# CITY OF ALBUQUERQUE

June 13, 2024

**Re: Dutch Bros Coffee 7330 San Antonio Dr NE**  
**Traffic Impact Study (E19D025C2)**  
Engineer's Stamp 4-12-24  
Via email [buy@barghausen.com](mailto:buy@barghausen.com), [joseph@halesengineering.com](mailto:joseph@halesengineering.com)

Site Plan

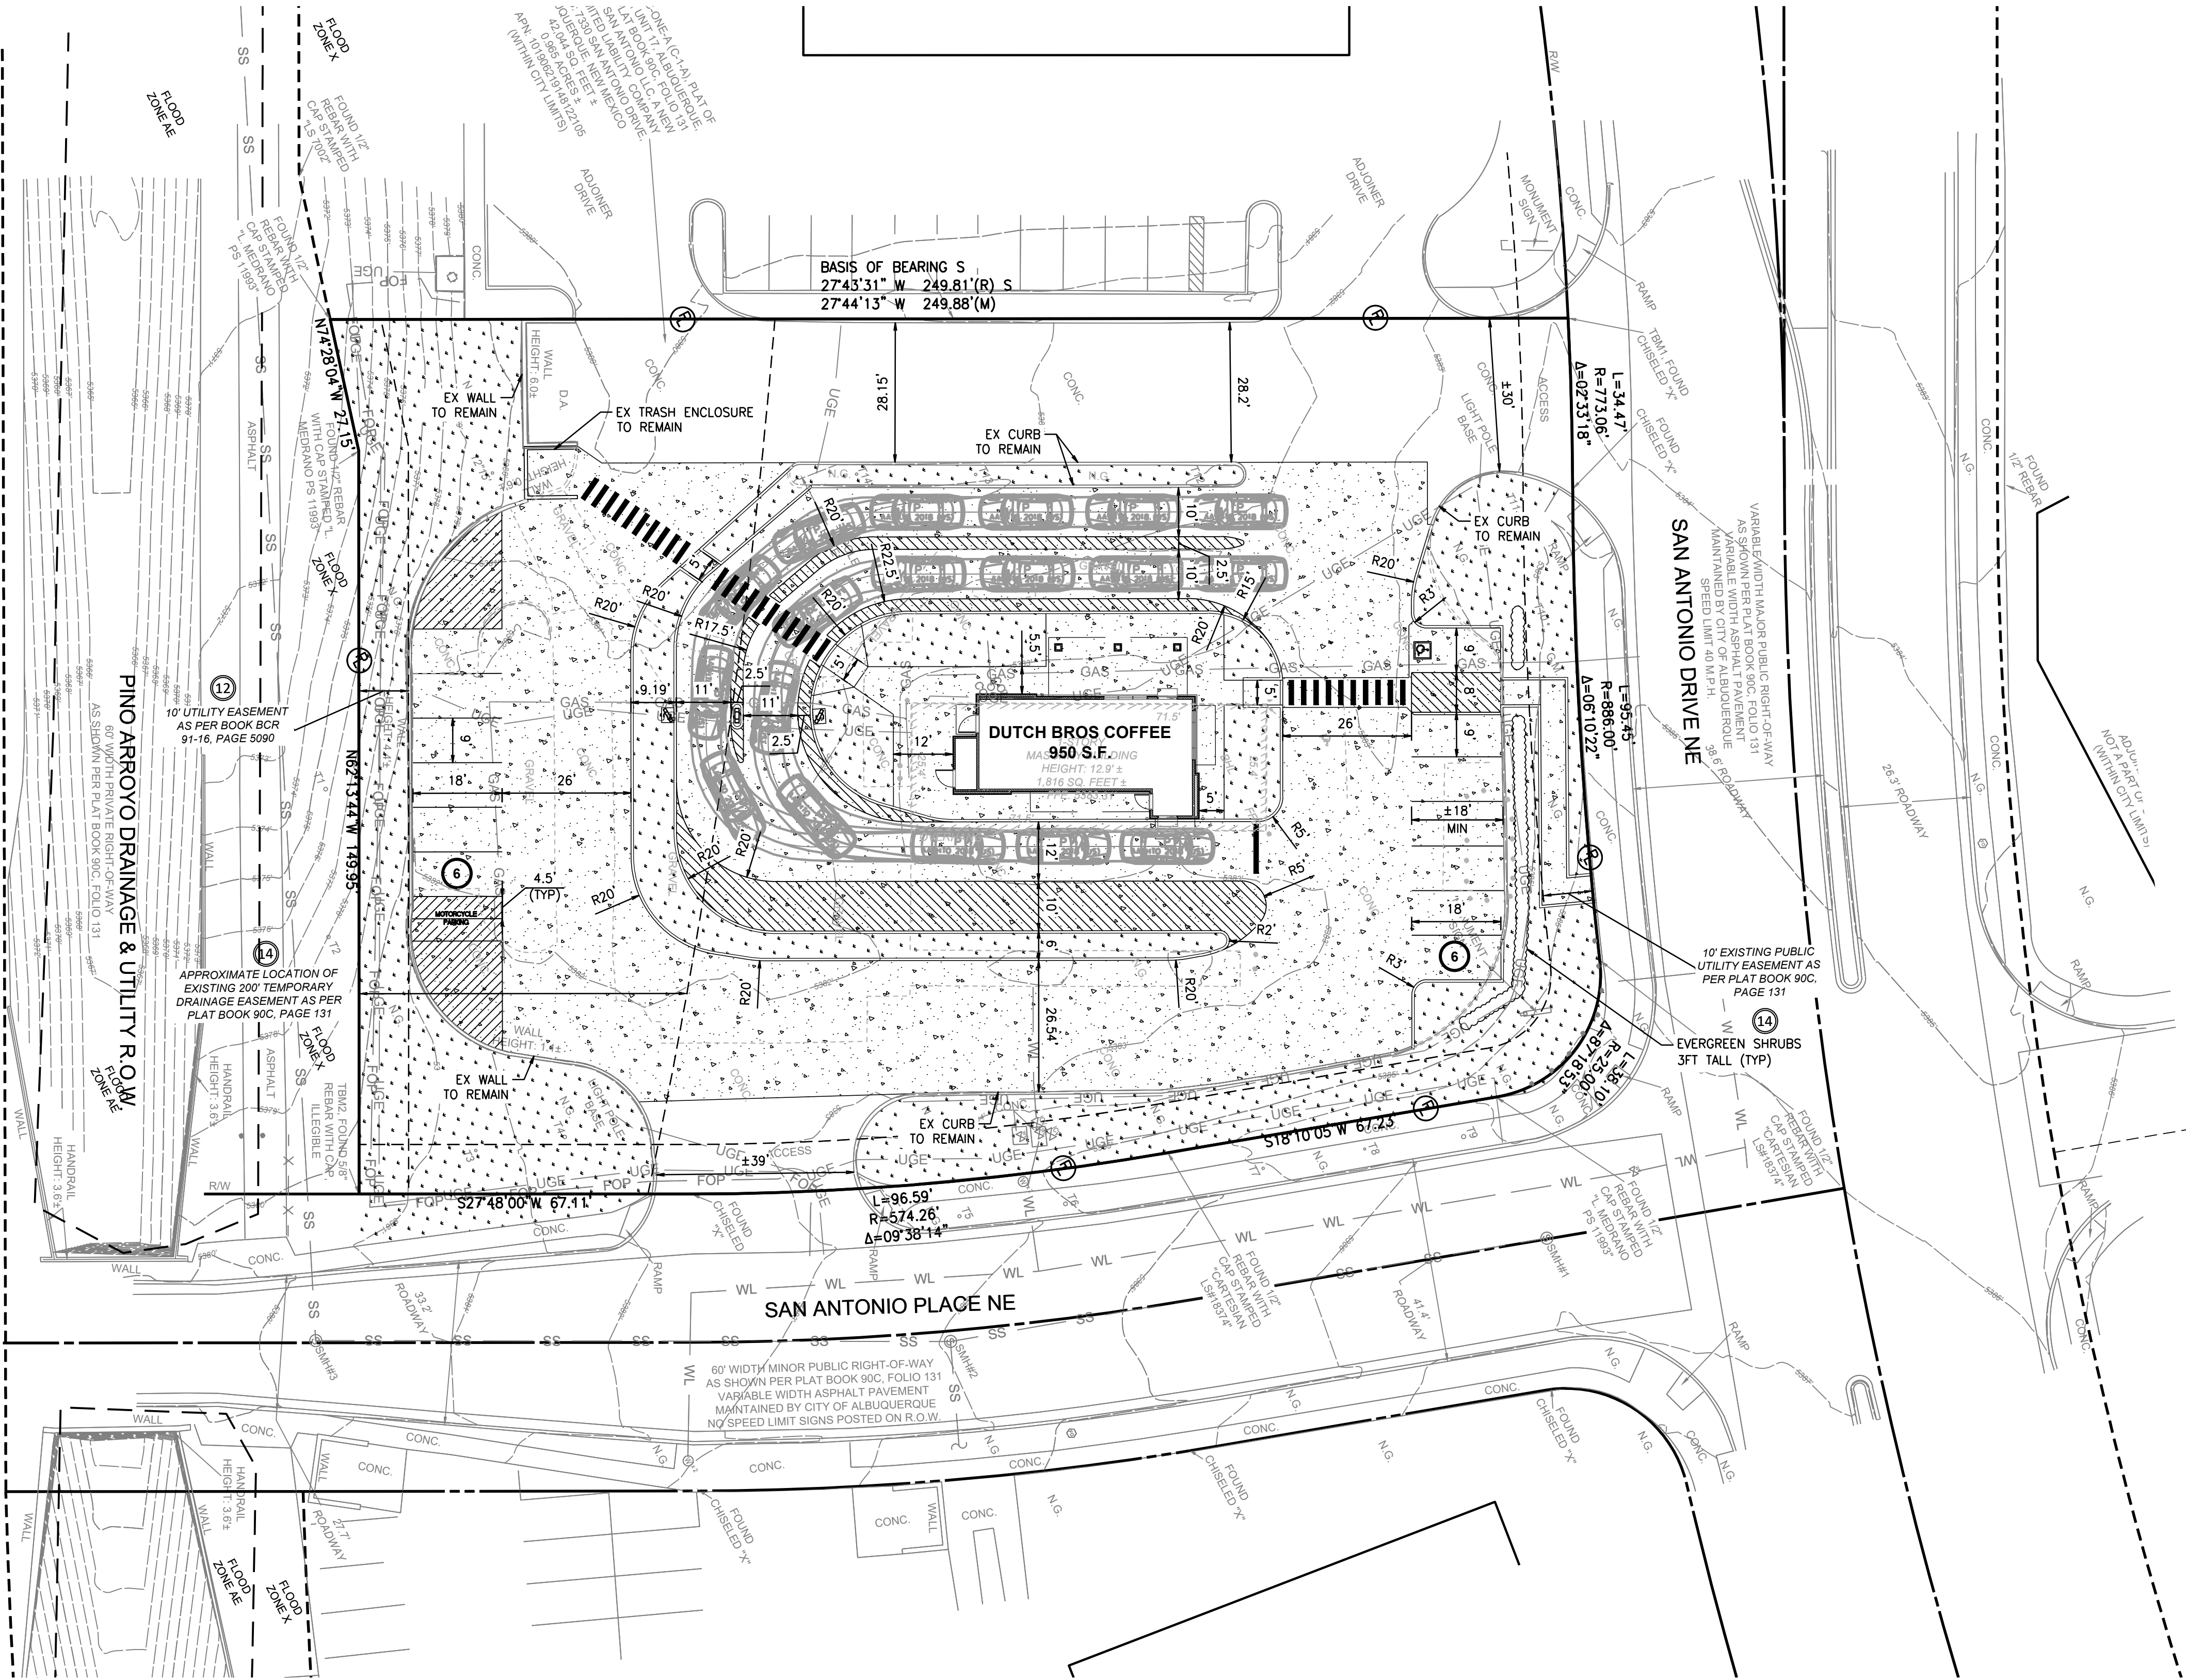
1. To prevent the queue from backing up onto San Antonio Dr. The access in the northwest corner of the site off of the access drive west of the site should be closed and the site accessed at the southwest area off the west access drive and southeast off of San Antonio Place.

3. The 28.15' drive aisle along the west side of the site should not allow parking as the full width is needed for 2-way traffic. Paint curbs and pavement and provide signage, or similar, for "NO PARKING".

Title: PROPOSED OFFSITE IMPROVEMENTS  
7330 SAN ANTONIO DR NE  
ALBUQUERQUE, NM 87109

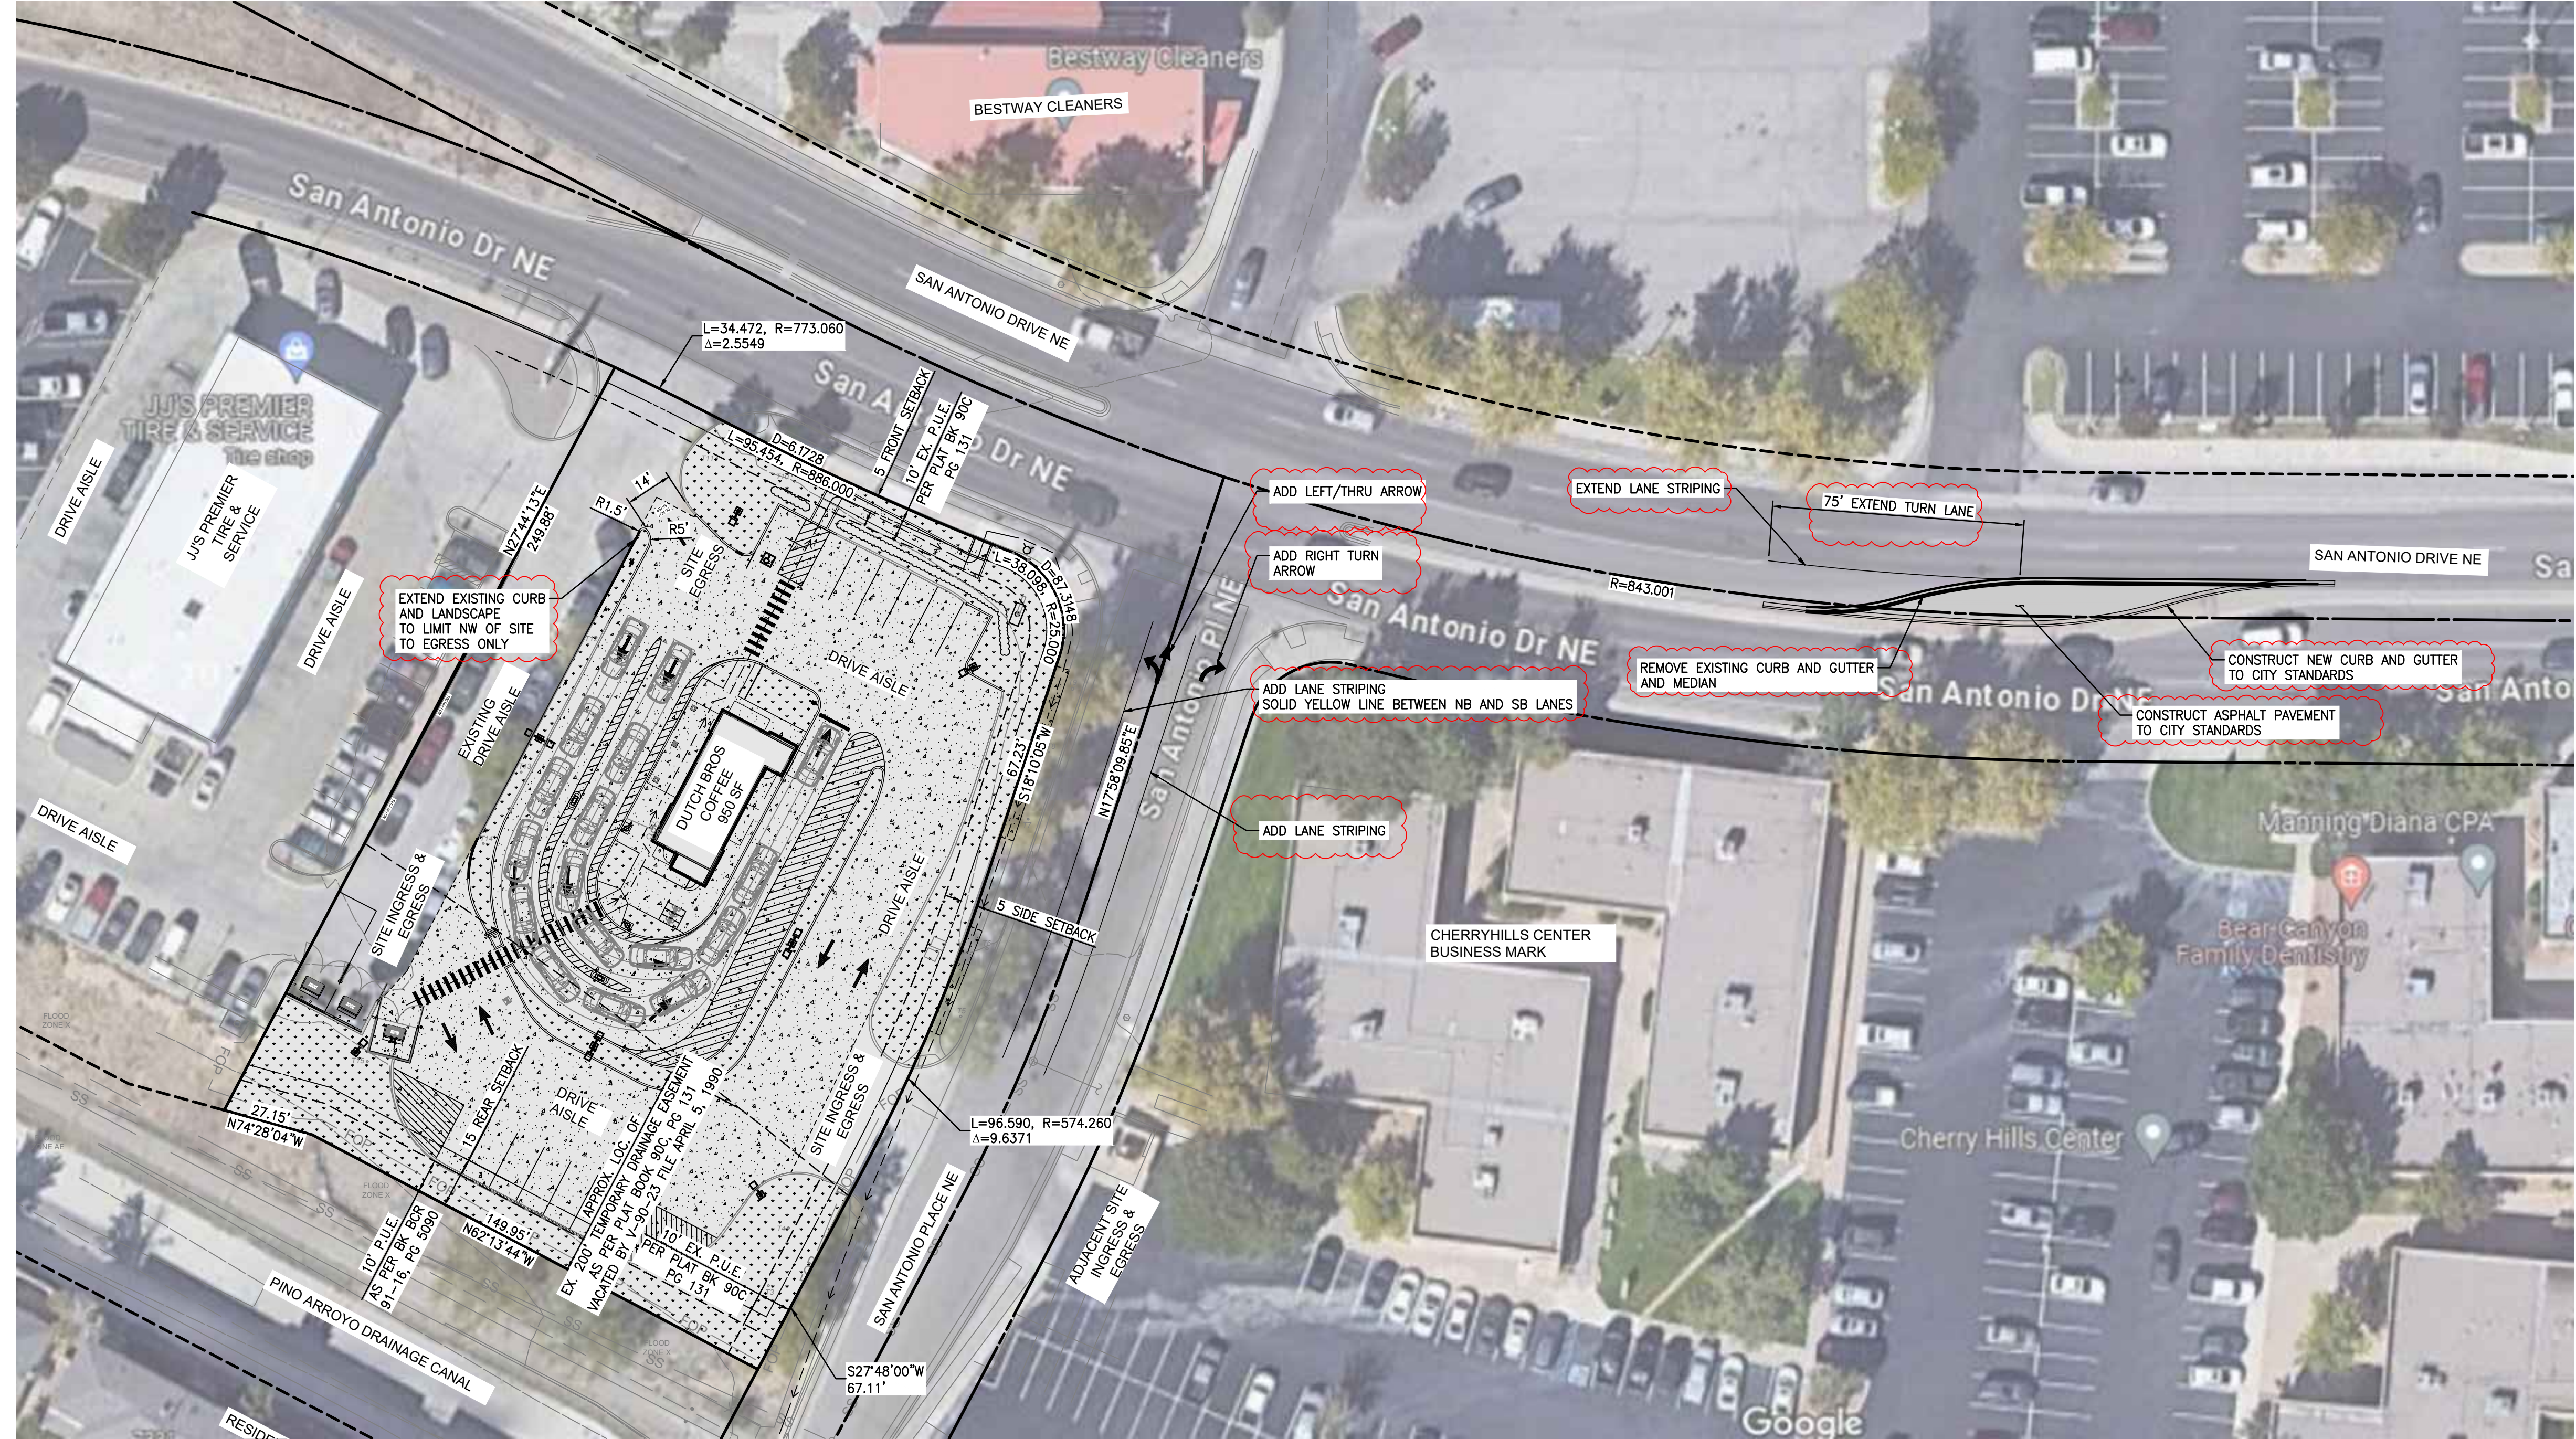
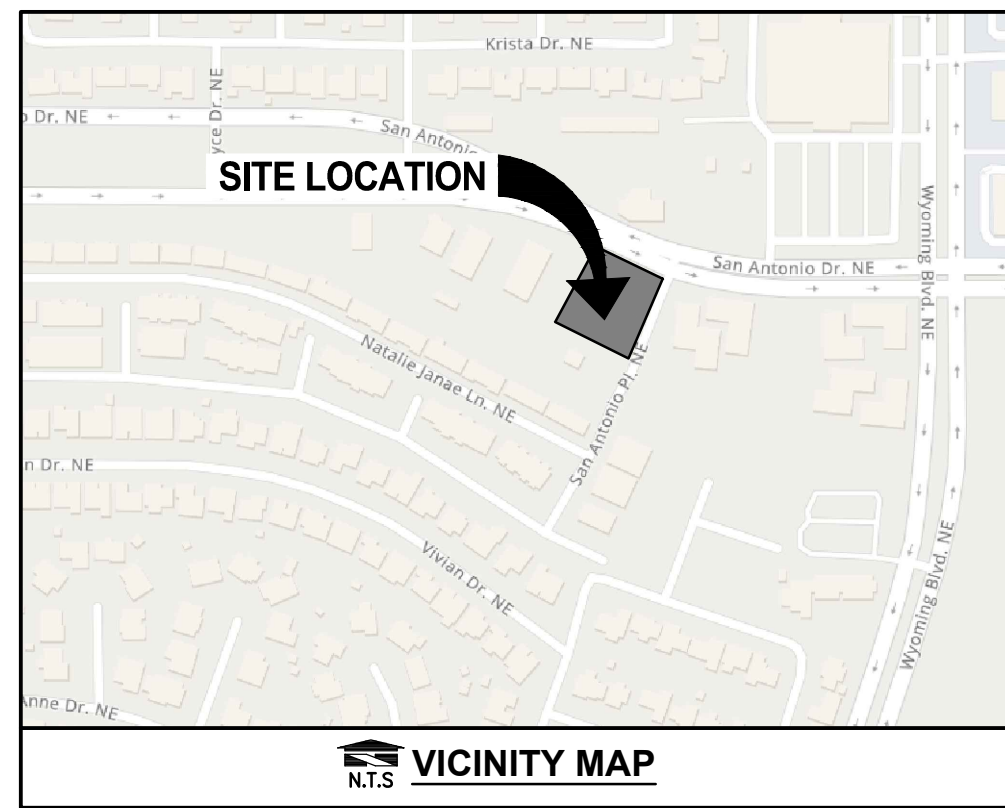
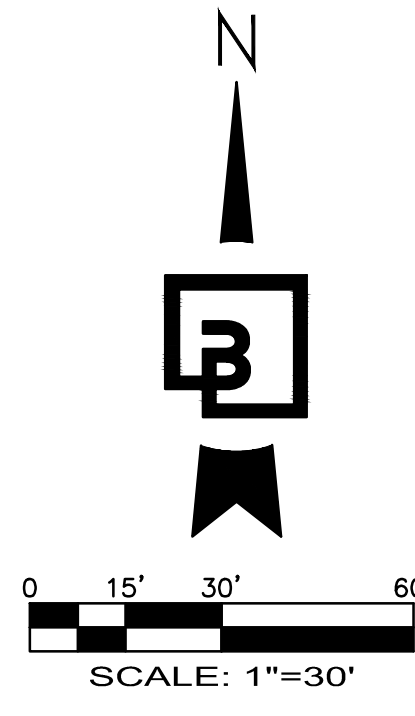
2. To minimize delays for drivers turning right onto eastbound Wyoming and provide lane clarification for the left-thru movement and right turn movement, construct pavement markings on San Antonio Pl at the northbound approach to San Antonio Dr.

4. The existing westbound left-turn lane at the San Antonio Place NE/ San Antonio Dr NE intersection should be extended as far as it can be extended to support the additional traffic making this movement. It appears approximately 75' of storage can be added.
